CITY OF ALBUQUERQUE

July 2, 2012

Re: Bruckner Truck Sales, Inc., Drainage Report and Grading Plan
Engineer's Stamp dated: 6/21/12 (H-18/D018)

ENGINEER'S SEAL RONALD R. BOHANNAN P.E. #7868	BRUCKNERS TRUCK SALES		DRAWN BY BJF
	DETAIL SHEET		DATE 7/6/12
	TIERRA WEST, LLC 5571 MIDWAY PARK PLACE NE ALBUQUERQUE, NM 87109 (505) 858-3100 www.tierrowestllc.com		2011073_DTB
			SHEET # C8 JOB # 2011073

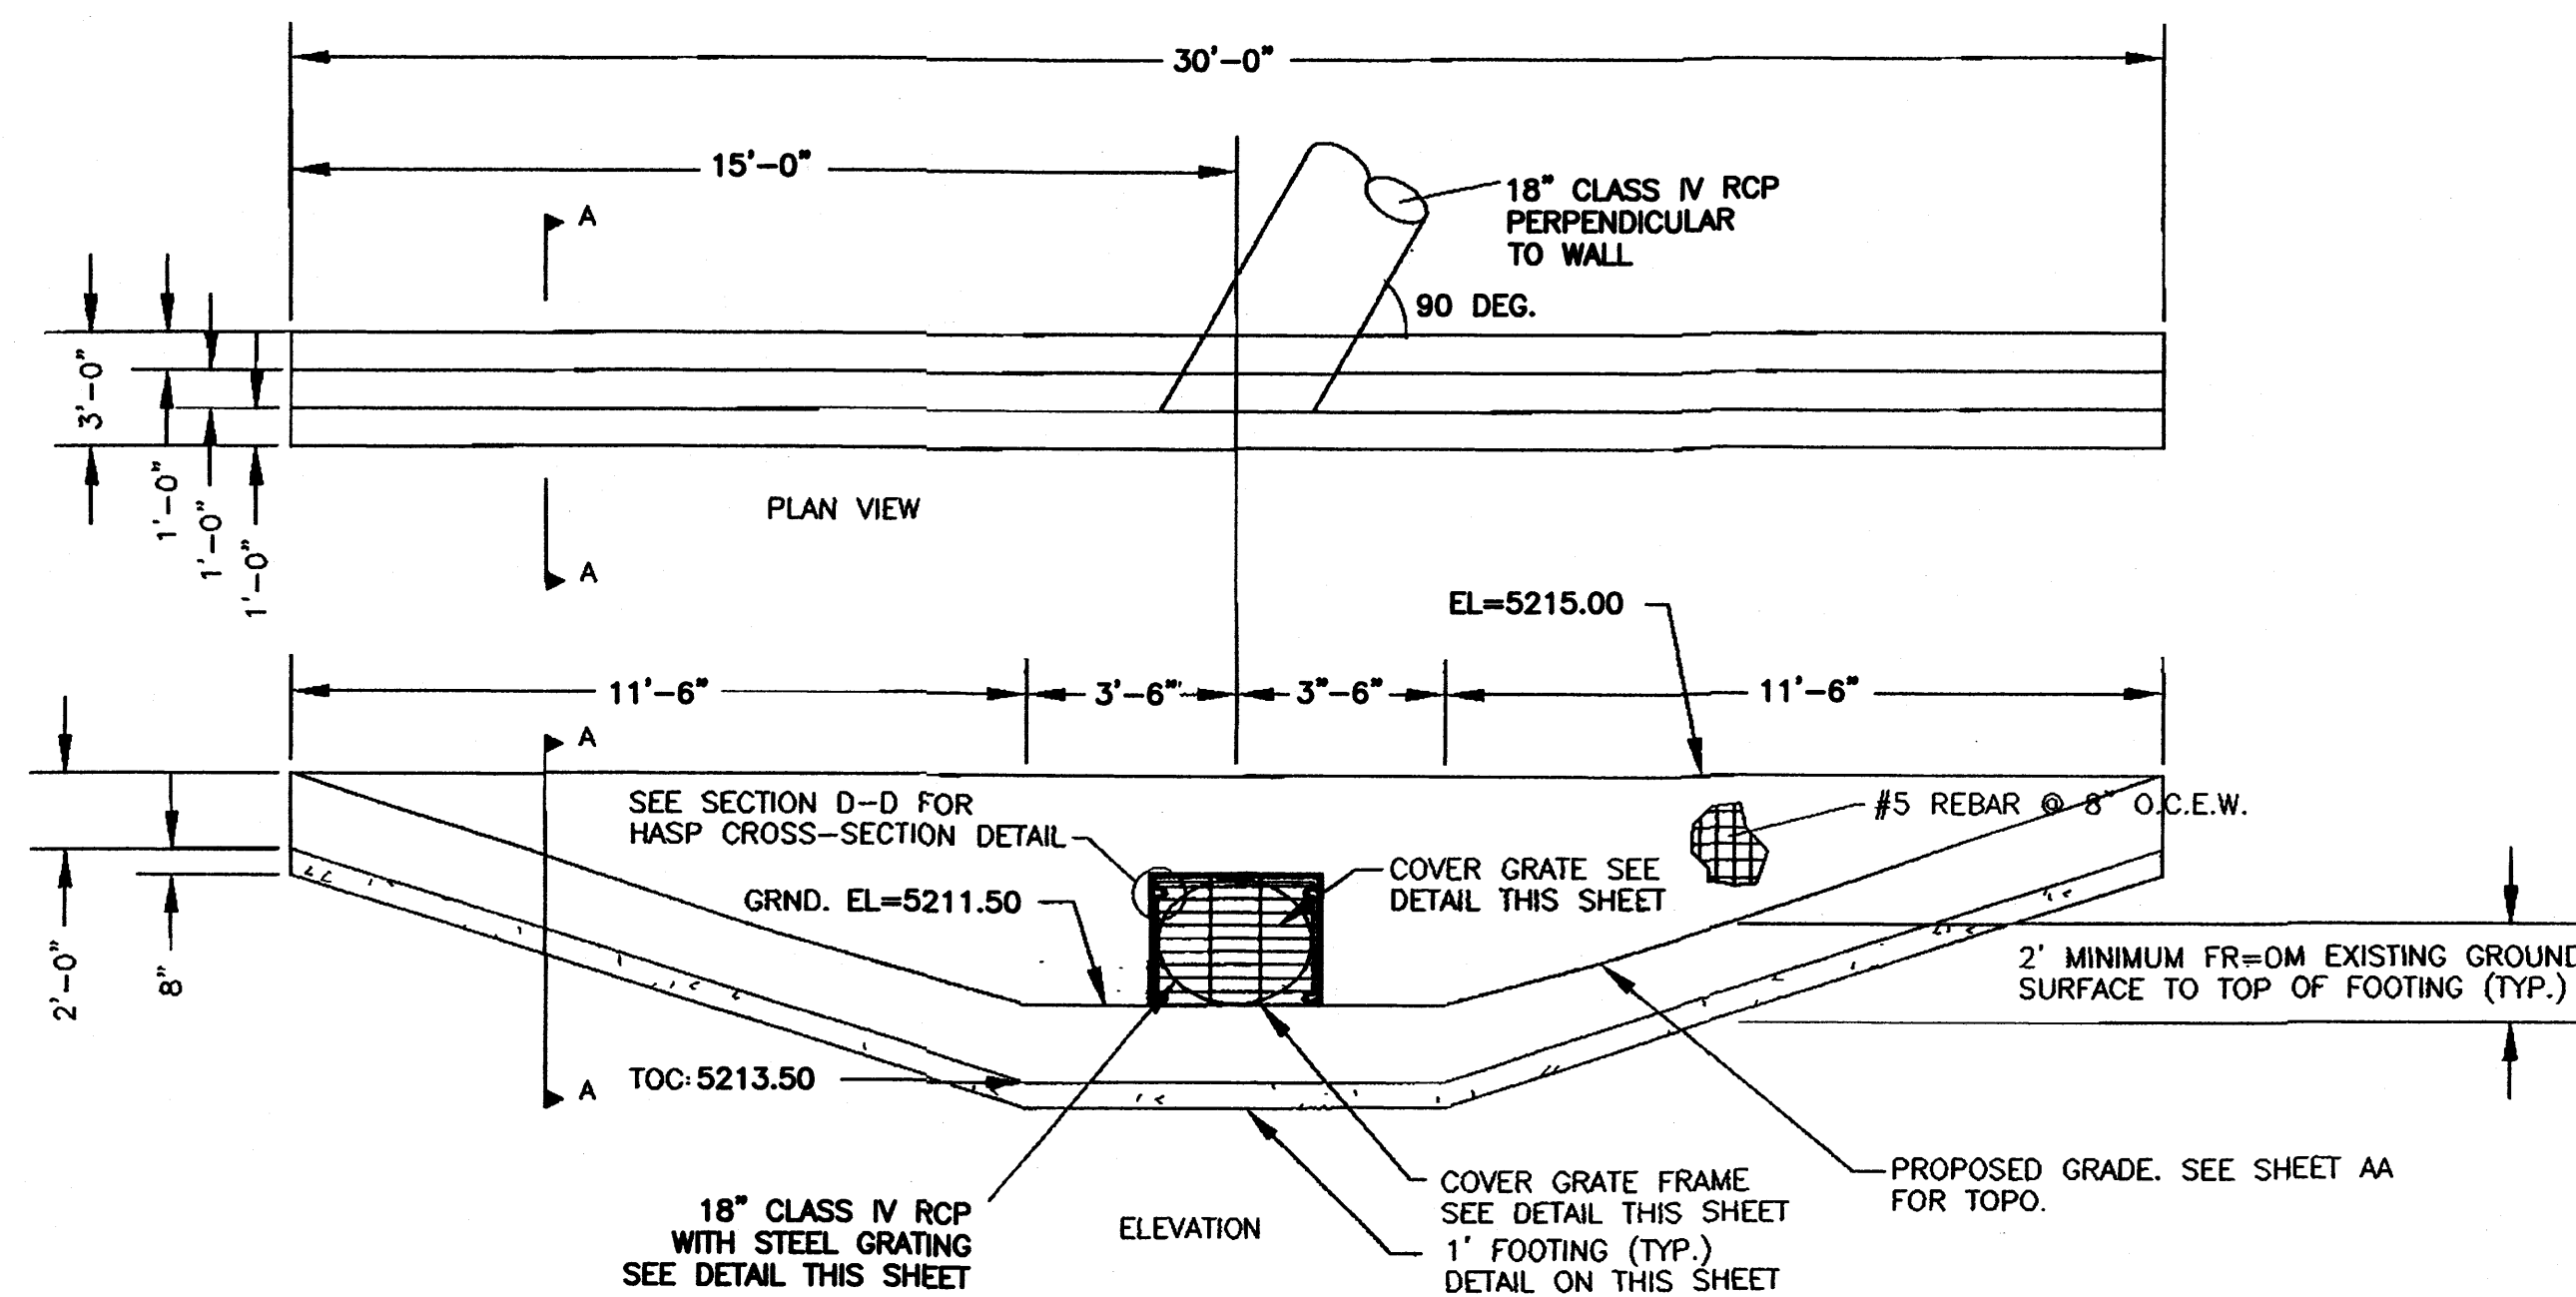
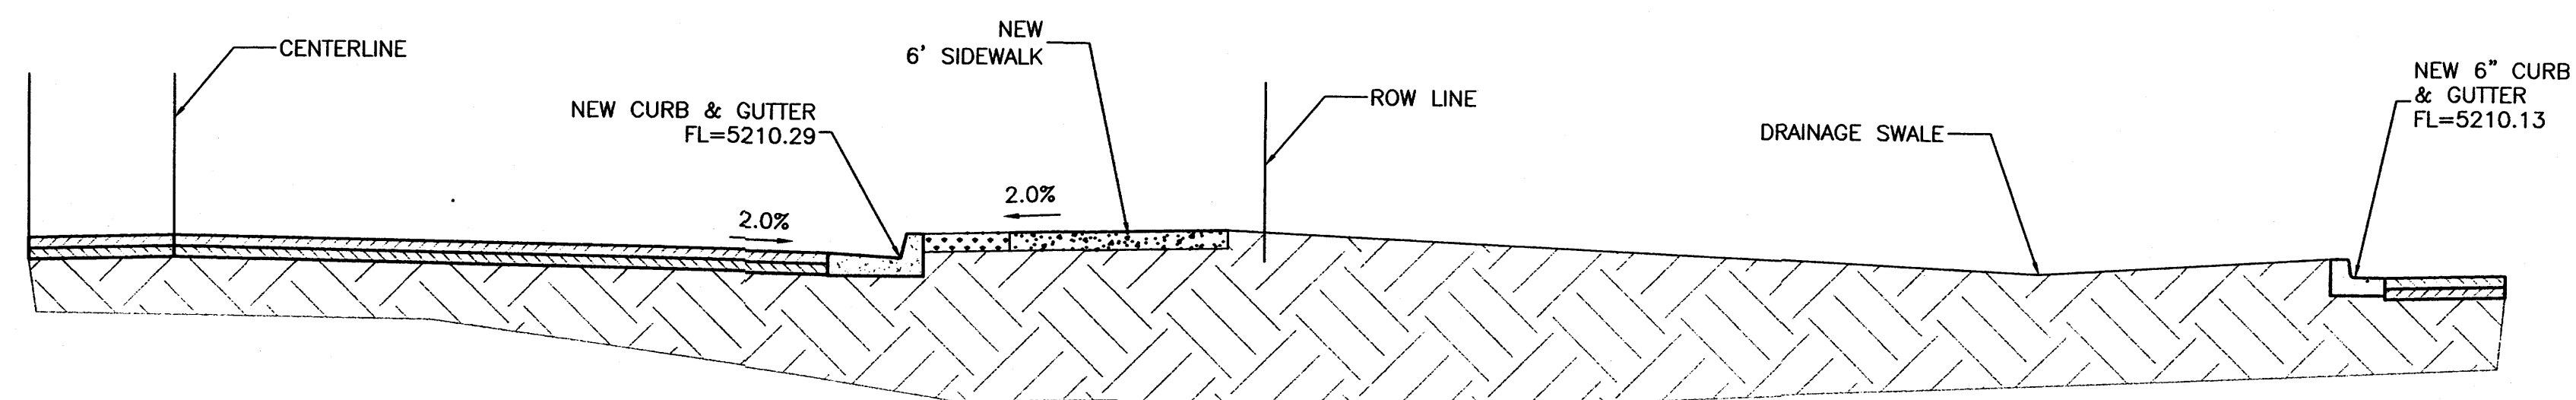
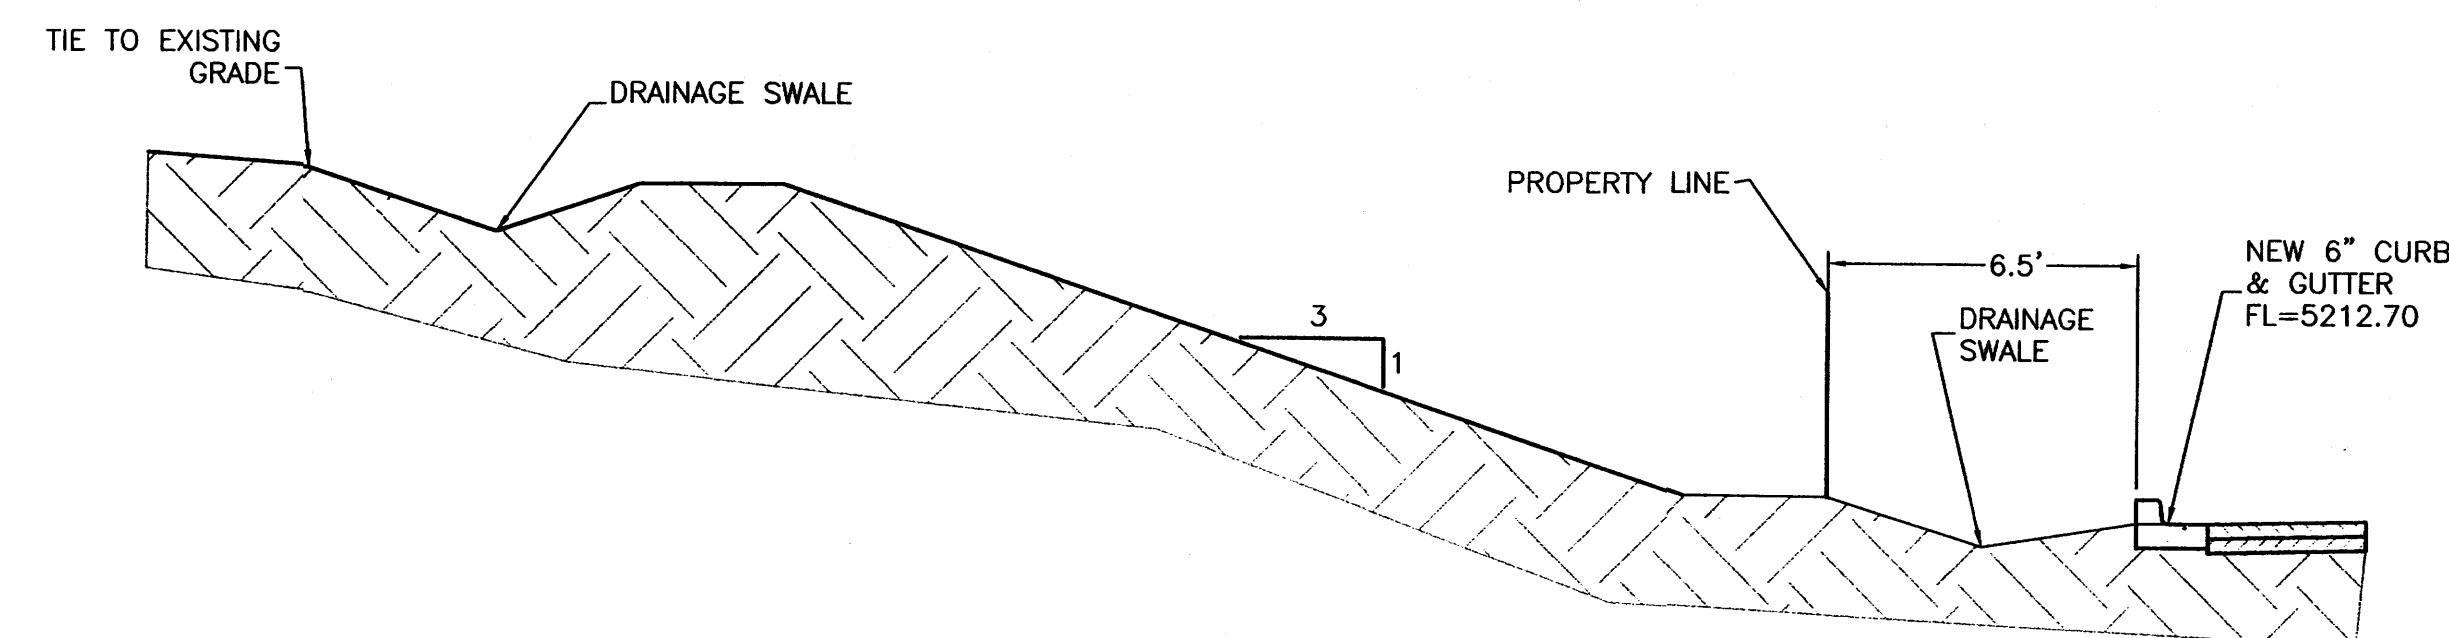
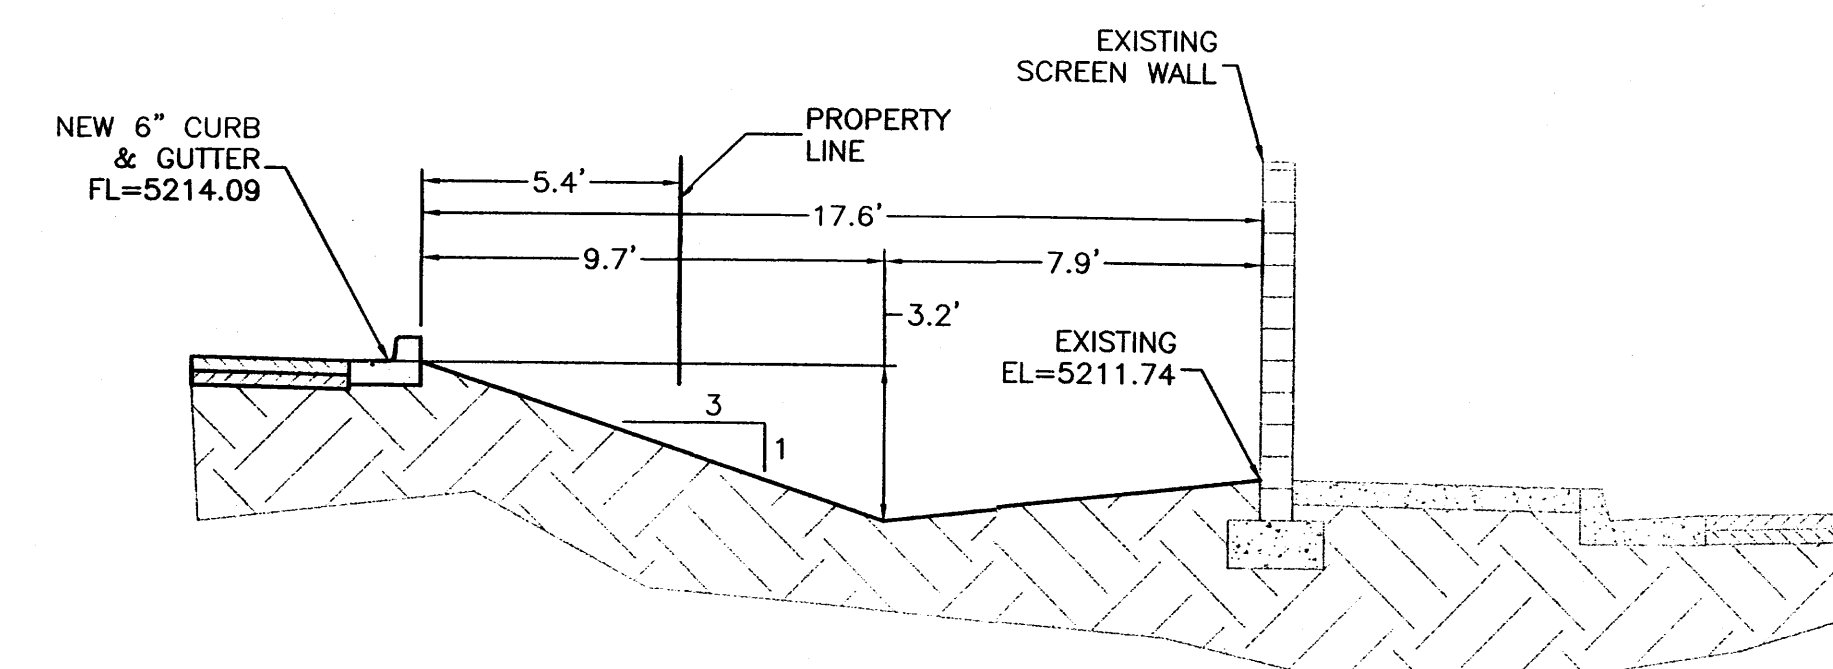
- Please provide a detail of the area around the cul-de-sac so it is easier to see the proposed grades. The report and detail sheet indicate a water quality inlet in a sedimentation pond upstream of the cul-de-sac. This is not clear on the grading and drainage plan.
